WEST SUSSEX COUNTY COUNCIL CONSULTATION

TO:	Arun District Council FAO: Anita Gardner
FROM:	WSCC - Highways Authority
DATE:	14 April 2022
LOCATION:	Rustington Golf Centre Golfers Lane Angmering BN16 4NB
SUBJECT:	A/45/22/PL Erection of 167 No new homes in a mix of 1-4 bedroom properties (2-4 bedroom homes and 1 bedroom apartments), with associated landscaping, parking, open space, play areas, construction of a new vehicular access from Golfers Lane and all other associated development works (resubmission following A/129/21/PL). This application is a Departure from the Development Plan and is in CIL Zone 3 and is CIL Liable as new dwellings.
DATE OF SITE VISIT:	14th April 2022
RECOMMENDATION:	More Information
S106 CONTRIBUTION TOTAL:	See below for breakdown.

Appendix A - Site Layout

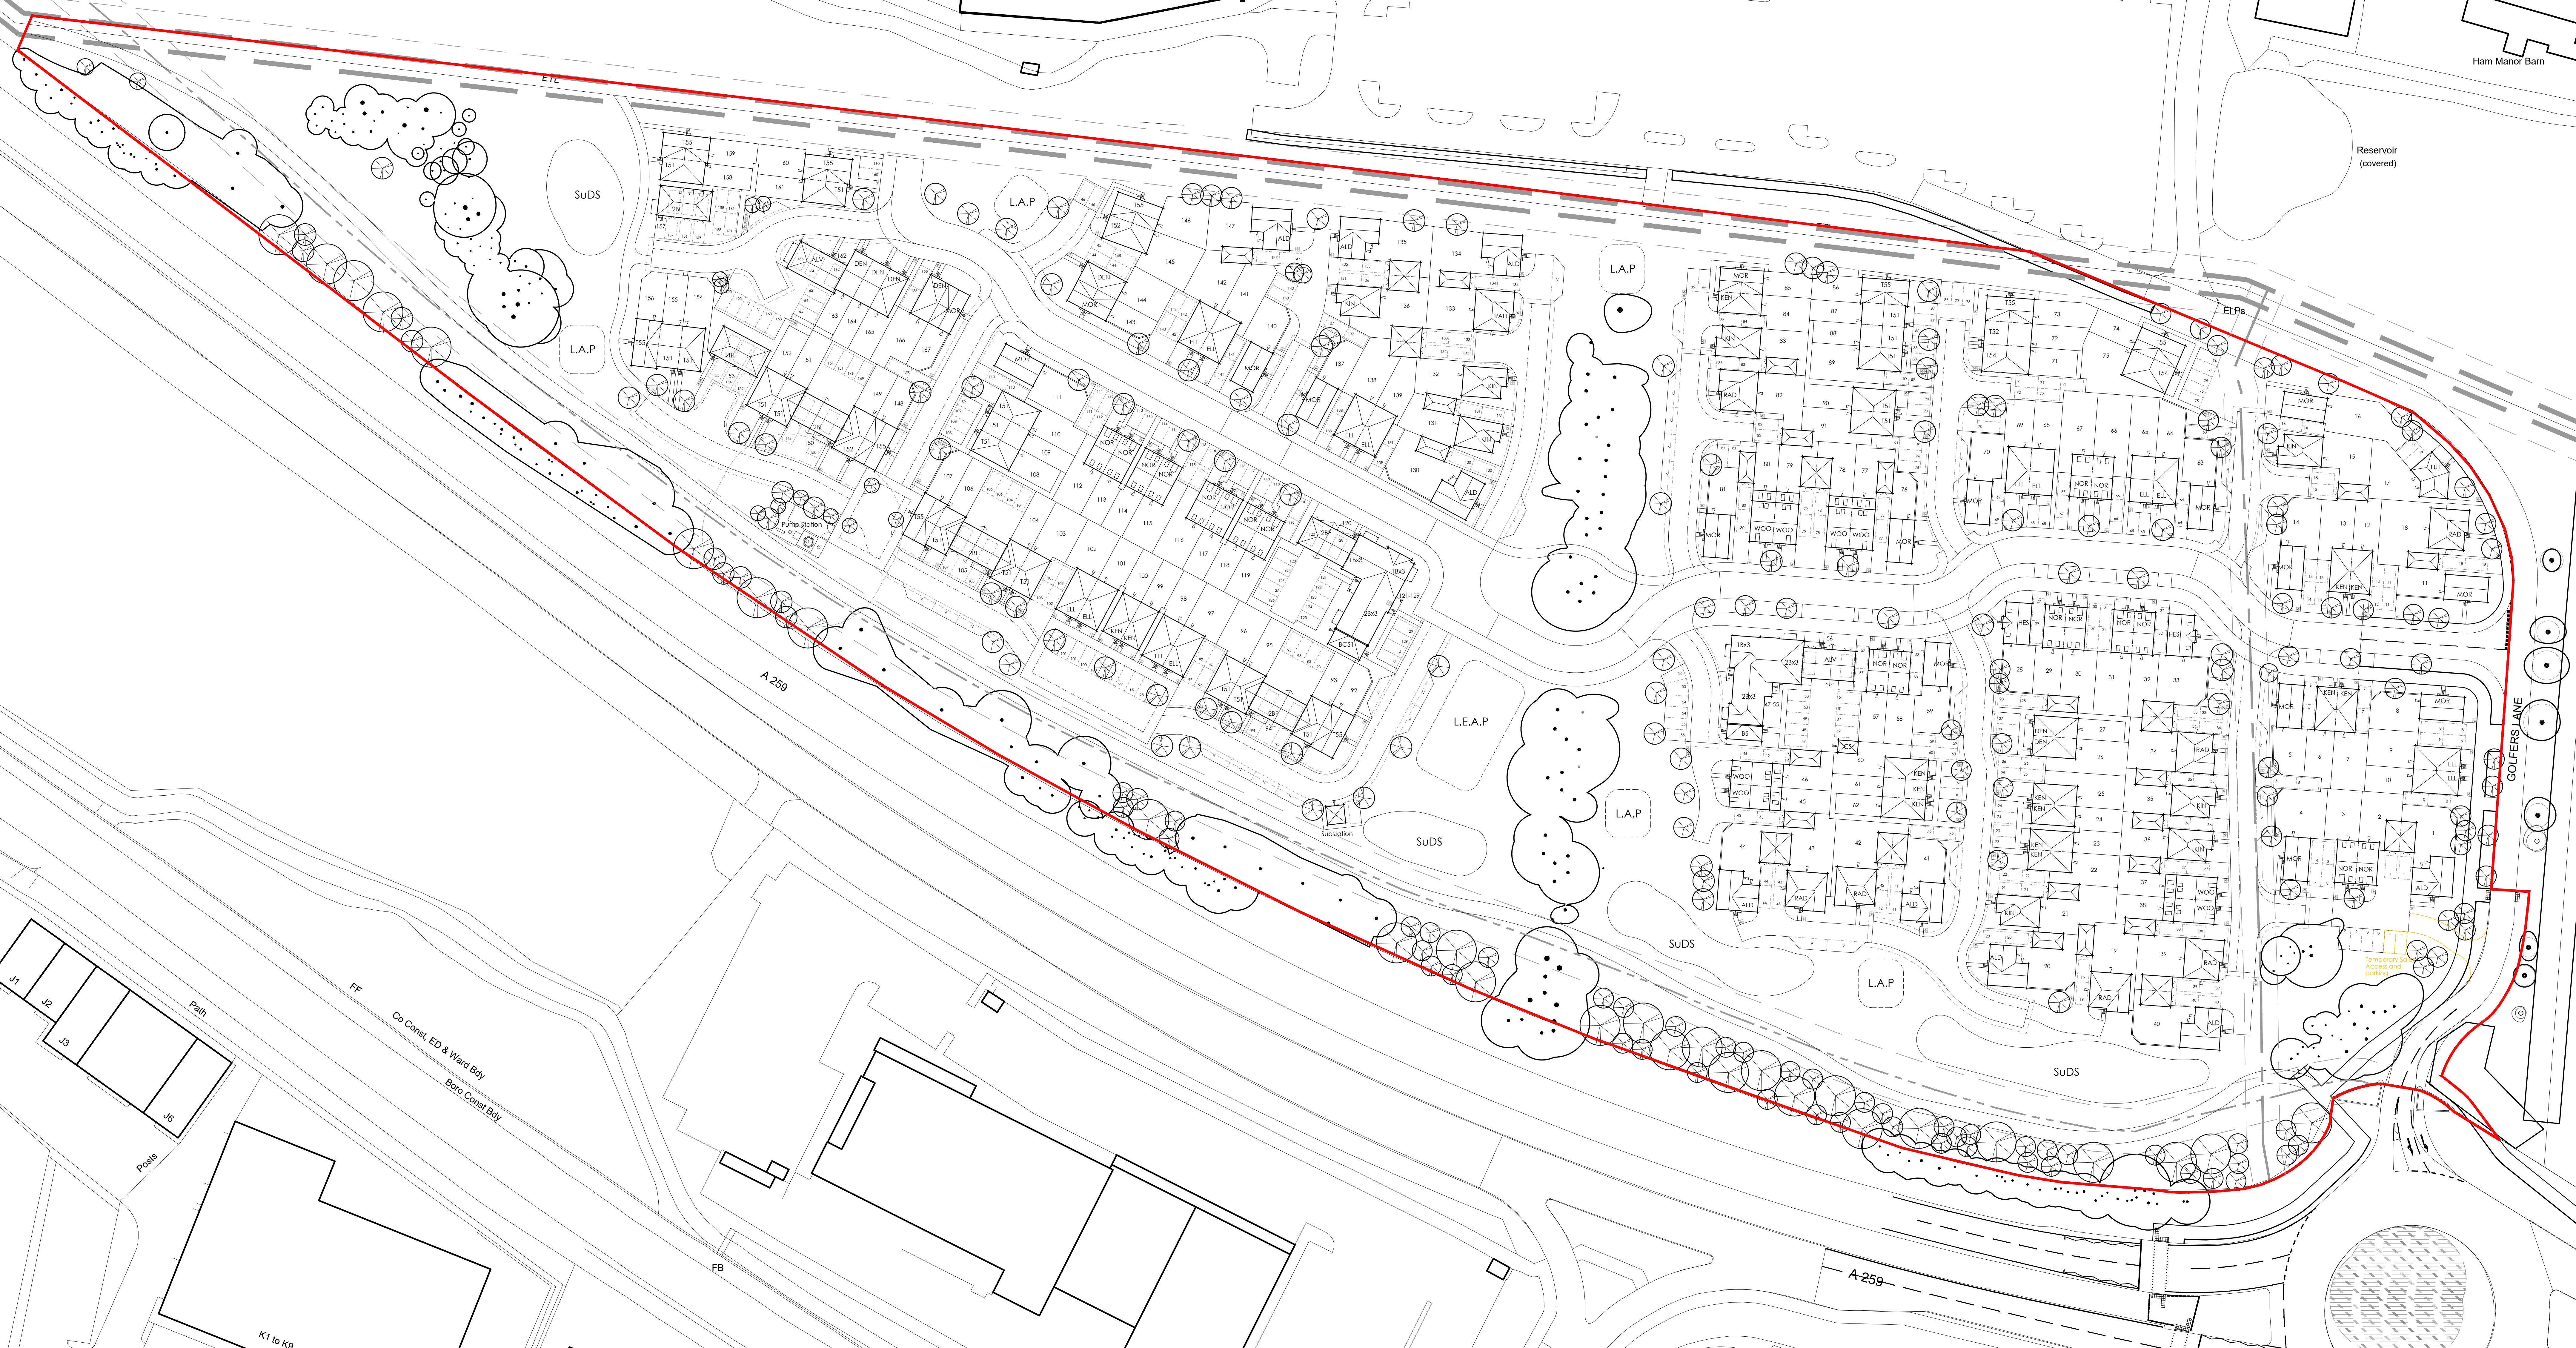
23. The proposed internal road layout comprises a mix of segregated foot/carriageways and shared surfaces on those lightly trafficked areas. The main spine road is indicated as being 6 metres wide along its entire length. The areas of shared surface are of variable width but the majority are 6 metres from edge to edge. The broad layout arrangements are considered to comply with the guidance within Manual for Streets.

24. With respects to more detailed aspects of the layout,
25. The carriageway alignment in front of plot 130 is less than ideal. The arrangement is recognised as being proposed to retain the existing tree belt and would at least act as a speed reducing feature.

26. A 3 metre wide shared foot/cycle way appears to be proposed along the southern side of the spine road. The route then connects through to the proposed foot/cycle way extension alongside the A259. In terms of the route within the development, given the low speed/lightly trafficked nature of the development, a dedicated shared use route would not be necessary. Based on the guidance within the LTN 1/20, on-road conditions will be such that all users could use the carriageway. It is acknowledged that the inclusion of this route would provide for some users albeit the majority would use the carriageway.

27. A pedestrian route is shown along the southern perimeter of the development connecting to Golfers Lane. The route also extends up to the site's western most boundary and then appears to continue beyond the site. Confirmation would be sought as to whether this is correct and how far this route may then continue beyond the site boundary. There would be particular interest in this route if it connects to public right of way number 2160 which runs to the immediate west of the development. Within the TA, the applicant has examined and ruled out the possibility of the development increased use of PROW 2160 where this crosses the A259 primarily as there is no direct link from the site to the right of way. However the proposed pedestrian route suggests that a connection to the right of way might now be proposed.

Scale 1:500 @ A1	Date APRIL 2021	Drawn TDM	Checked NB
Drawing No A351-PLN-1-4005			Revision A

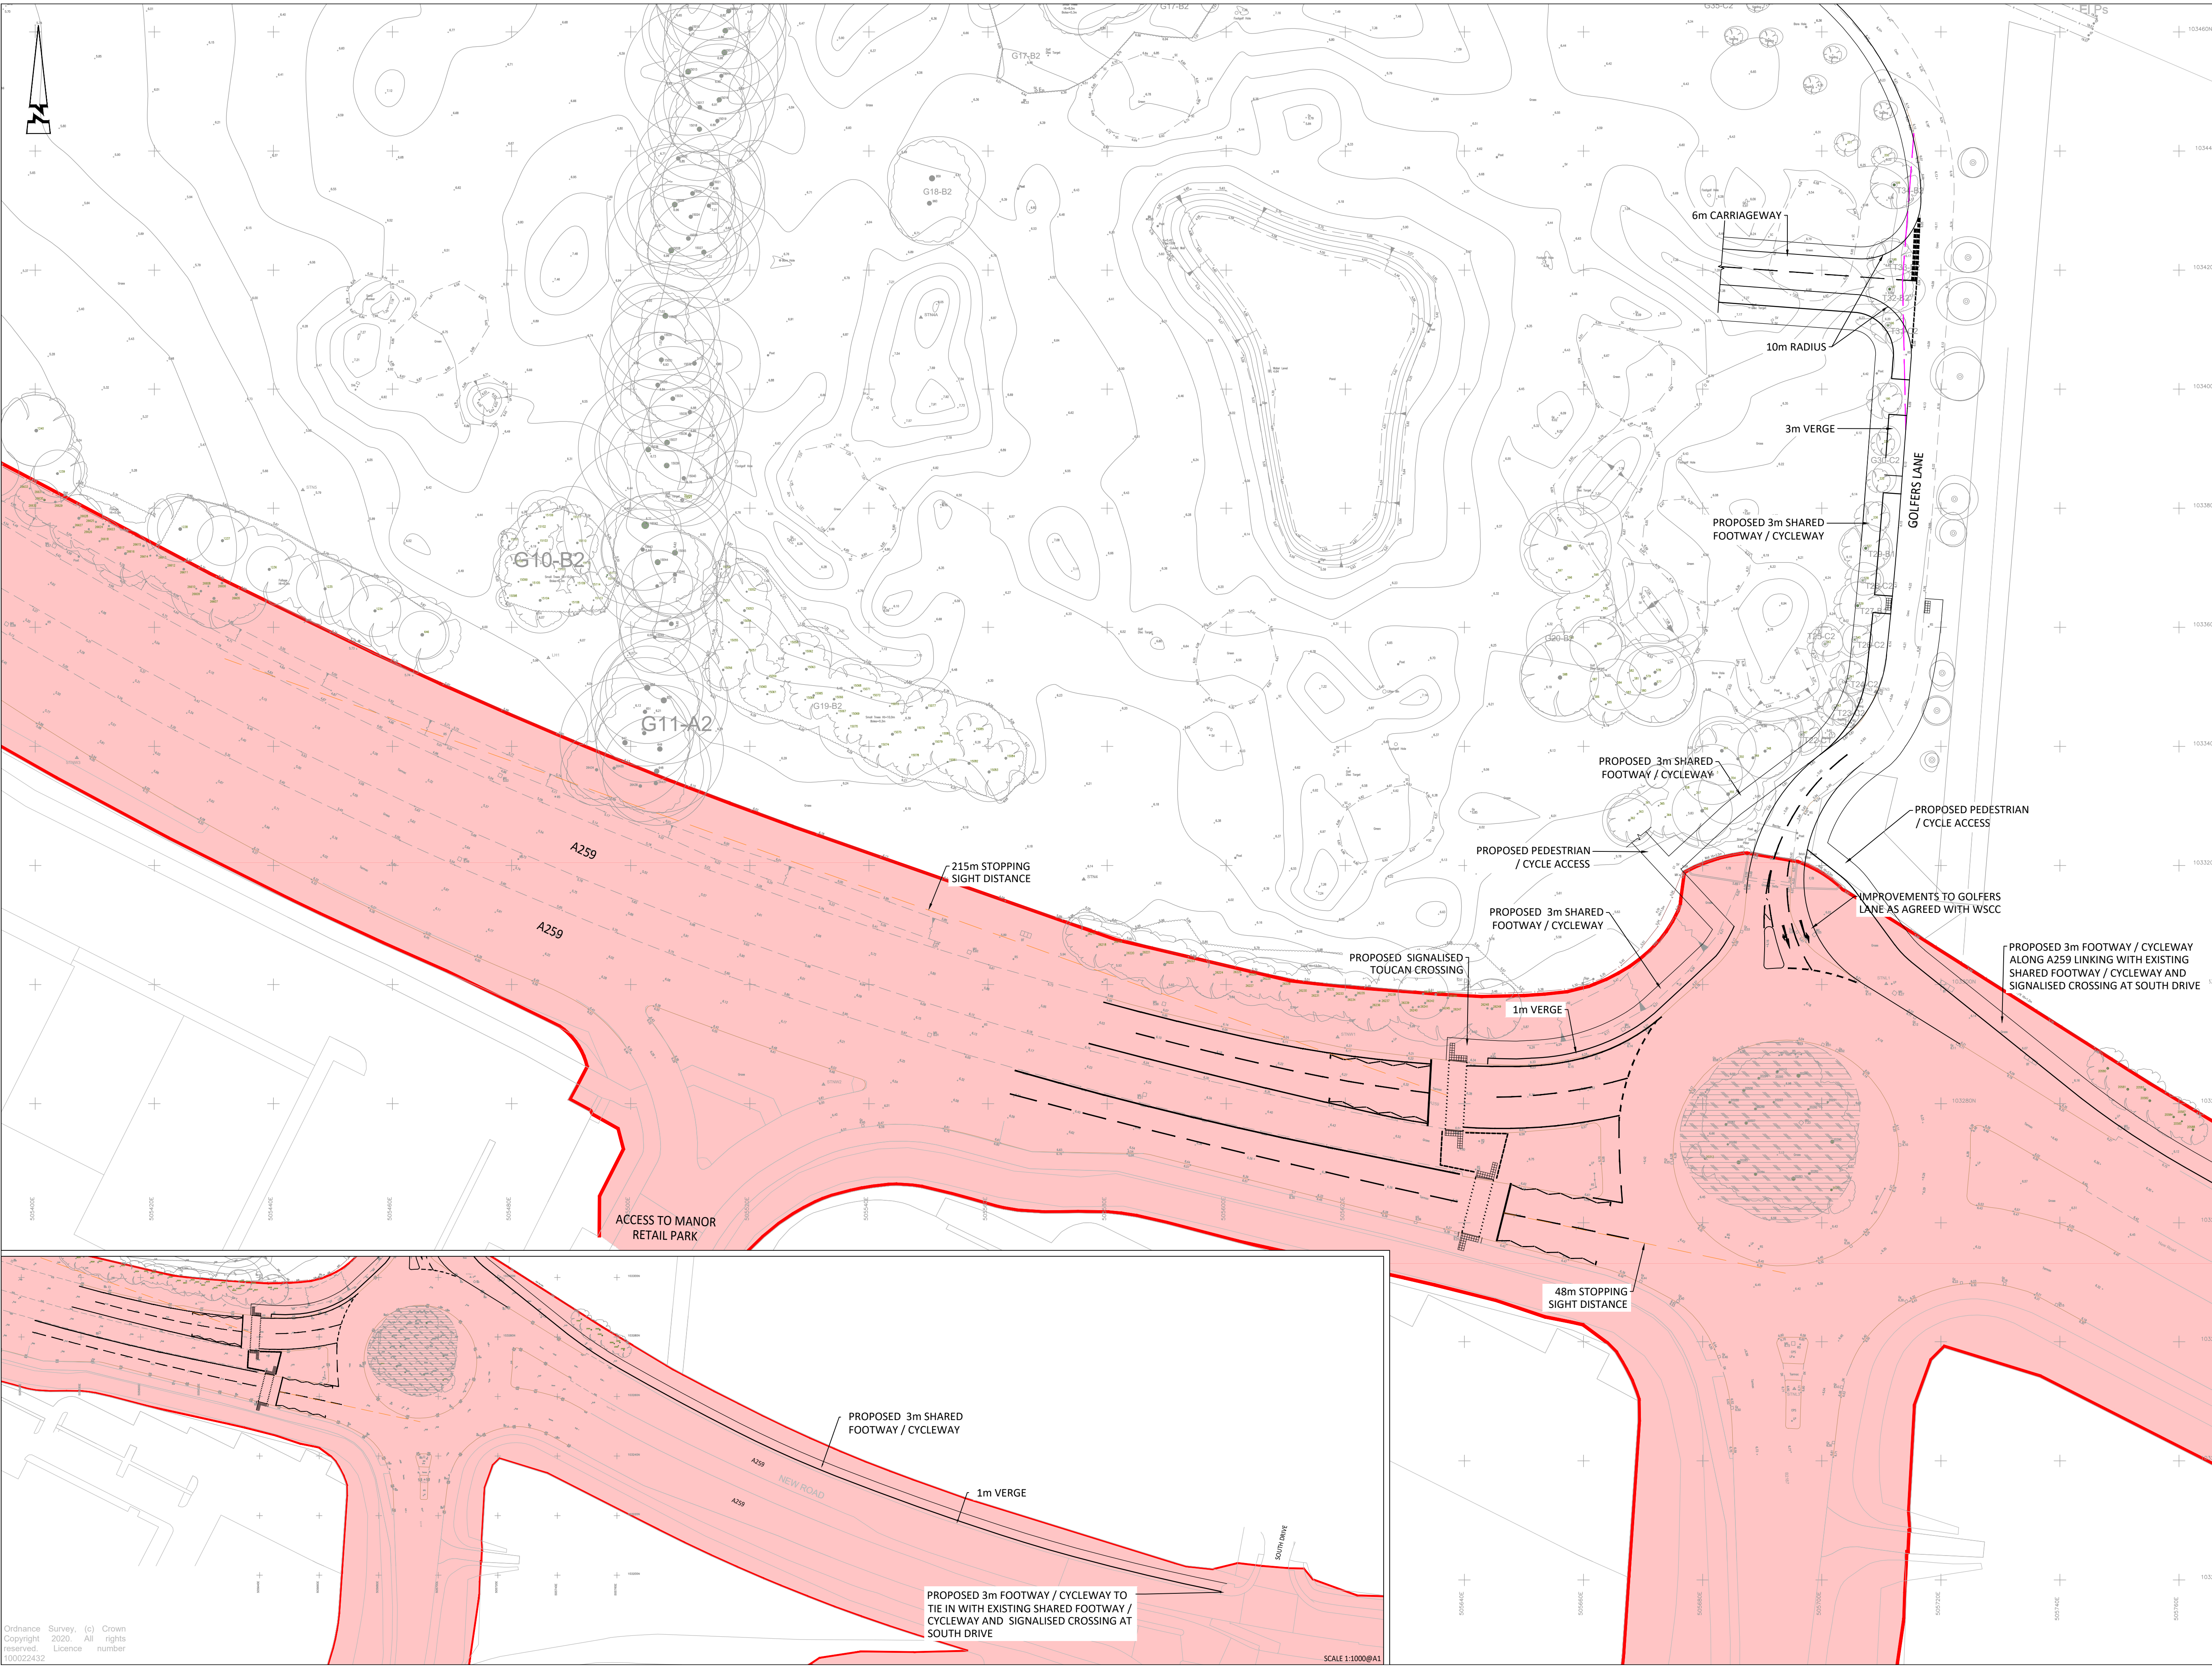
highway. No permissions would be required from WSCC Highways to enable any alterations to Golfers Lane. The form of access is considered appropriate, however the junction radii (of 10 metres) is excessive. Given the nature of the majority of traffic expected to use it, the 10 metre radii are quite substantial and could be reduced. The junction in all other respects appears acceptable.

4. The site will access the wider highway network via the existing northern arm of the A259 Mill Lane Roundabout. Given this arm is existing and already in use, there are no in principle issues with the continued and more intensive use of this arm. Minor alterations are proposed to increase the width of the entry flare and thereby allow two vehicles to queue side by side on the Golfers Lane arm.
5. Access by non-vehicular modes are covered in the following section.

9. The developer is also proposing a new signalised crossing to the west of the A259 Mill Lane Roundabout. The crossing will be for both pedestrians and cyclists (Toucan crossing). WSCC has commented on the principle of a crossing in this location as part of the pre application comments. In principle and providing all necessary design criteria are met, at grade controlled crossings are acceptable with similar crossings proposed as part of the

10. In terms of the design, current design standards do not allow for standalone signalised crossings on roads where 85th percentile traffic speeds are greater than 50mph. The proposed crossing is within the existing 50mph speed limit, which changes to 70mph a short distance to the west. The crossing is also close to the A259 Mill Lane Roundabout, which may result in reduced approach speeds. Given the proximity of the crossing to the roundabout, the applicant has been advised to undertake speed surveys to determine 85th percentile speeds. The results of the speed survey are included in the TA.

14. Very limited consideration is given to the westbound approach to the crossing. Whilst traffic is likely to be travelling slower than that heading eastbound, the approach speed of 33mph quoted within the Designers Response to the Stage One Road Safety Audit doesn't appear to be supported by speed data. The stopping sight distance also appears to be based upon Manual for Streets, which given the context of the road is not considered appropriate. The applicant should clarify exactly what design standards have been given to the westbound approach to the crossing. This is a concern as drivers may not be anticipating the crossing or expecting to stop. The Road Safety Audit also appears to raise the westbound approach as a concern (although the audit appears to incorrectly reference 'eastbound' whereas the problem description seems to relate to 'westbound' traffic) with the recommendation to move the crossing further west. This recommendation hasn't been addressed by the designer.

15. Based on the information submitted, there remains concerns in terms of the appropriateness of the at-grade crossing given the high eastbound 85th percentile speeds and the lack of information in terms of the determination of the stopping sight distance for westbound traffic.
